WEST SUSSEX COUNTY COUNCIL CONSULTATION

TO:	Arun District Council FAO: Simon Davis	
FROM:	Highways, WSCC	
DATE:	26/09/2018	
LOCATION:	9, Westloats Lane, Bognor Regis, West Sussex, PO21 5JZ	
SUBJECT:	BR/219/18/PL Demolition of 1 No. existing building & erection of 2 No. 2 bedroom & 2 No. 1 bedroom dwellings.	
DATE OF SITE VISIT:	N/A	
RECOMMENDATION:	☒ Advice ☐ Objection ☐ Modification ☐ No Objection ☐ More Information ☐ Refusal	
S106 CONTRIBUTION TOTAL:	£N/A

Project Proposed Site Plan	Sheet 1
Date 2nd May 2018	
Scale 1 : 500

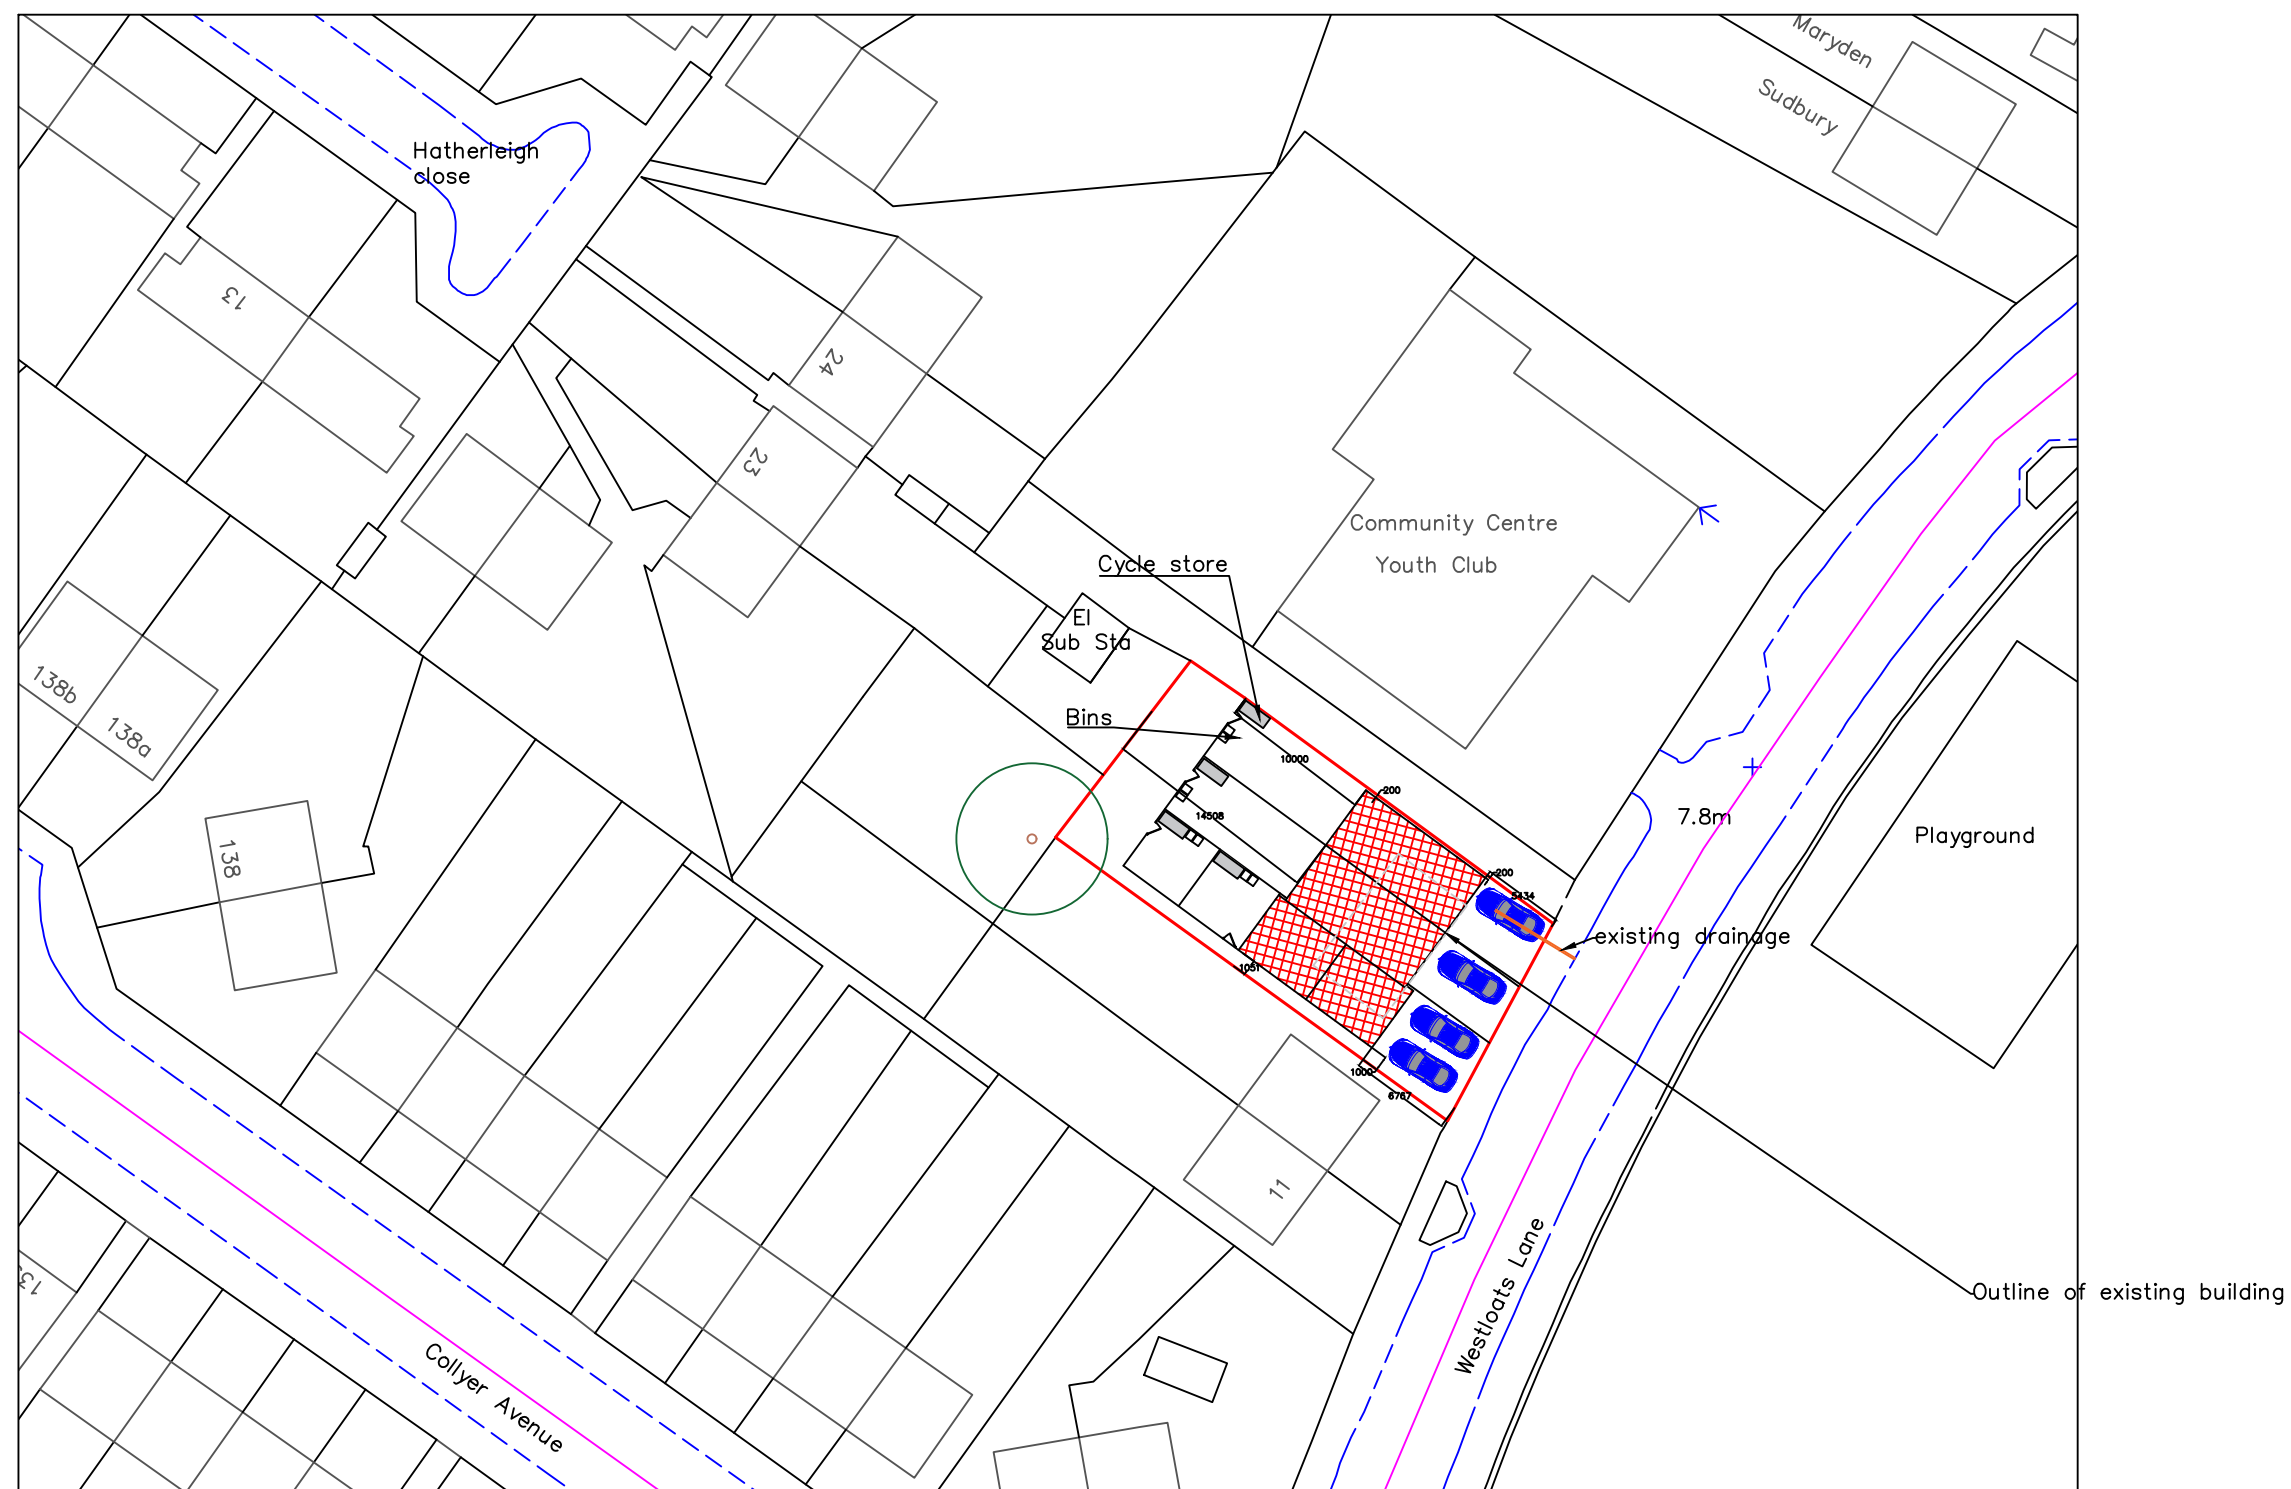
The site does not currently benefit from vehicular access onto Westloats Lane. The proposed plans indicate that vehicular access will be provided for the proposed dwellings however the extent of the proposed vehicle crossover(s) (VCO) has not been demonstrated on the plans. Details of the proposed VCO(s) can be secured via condition. The applicant should be aware that a licence will be required for the VCO(s) and must be constructed to a specification agreed with them.

The proposed plans indicate that a total of four parking spaces will be provided for the development - one space for each dwelling. The WSCC car parking demand calculator expects that six parking spaces would be required for a development of this size and location. Any overspill parking could be accommodated on-street. Whilst on-street car parking is limited in the immediate vicinity there are comprehensive parking restrictions prohibiting vehicles from parking in places that would be detrimental to highway safety. We would not consider that highway safety would be detrimentally affected through the proposed car parking provision. The Planning Authority may wish to consider the potential impacts of this development on on-street car parking from an amenity point of view.

A turn on site would be preferred, clearly though there is insufficient space to achieve this. However other properties appear to have similar arrangements which operate without evidence of highway safety concern.

The site is located within walking distance of local primary and secondary schools as well as local shops and bus stops providing access into Bognor Regis and Chichester. The applicant proposes secure and covered cycle storage within the rear gardens of each property in order to further encourage sustainable transport options.

No part of the development shall be first occupied until such time as the vehicular access has been constructed in accordance with plans and details to be submitted to and approved in writing by the Local Planning Authority.

No part of the development shall be first occupied until the car parking has been constructed in accordance with the approved site plan. These spaces shall thereafter be retained at all times for their designated purpose.

No part of the development shall be first occupied until covered and secure cycle parking spaces have been provided in accordance with the approved plan.
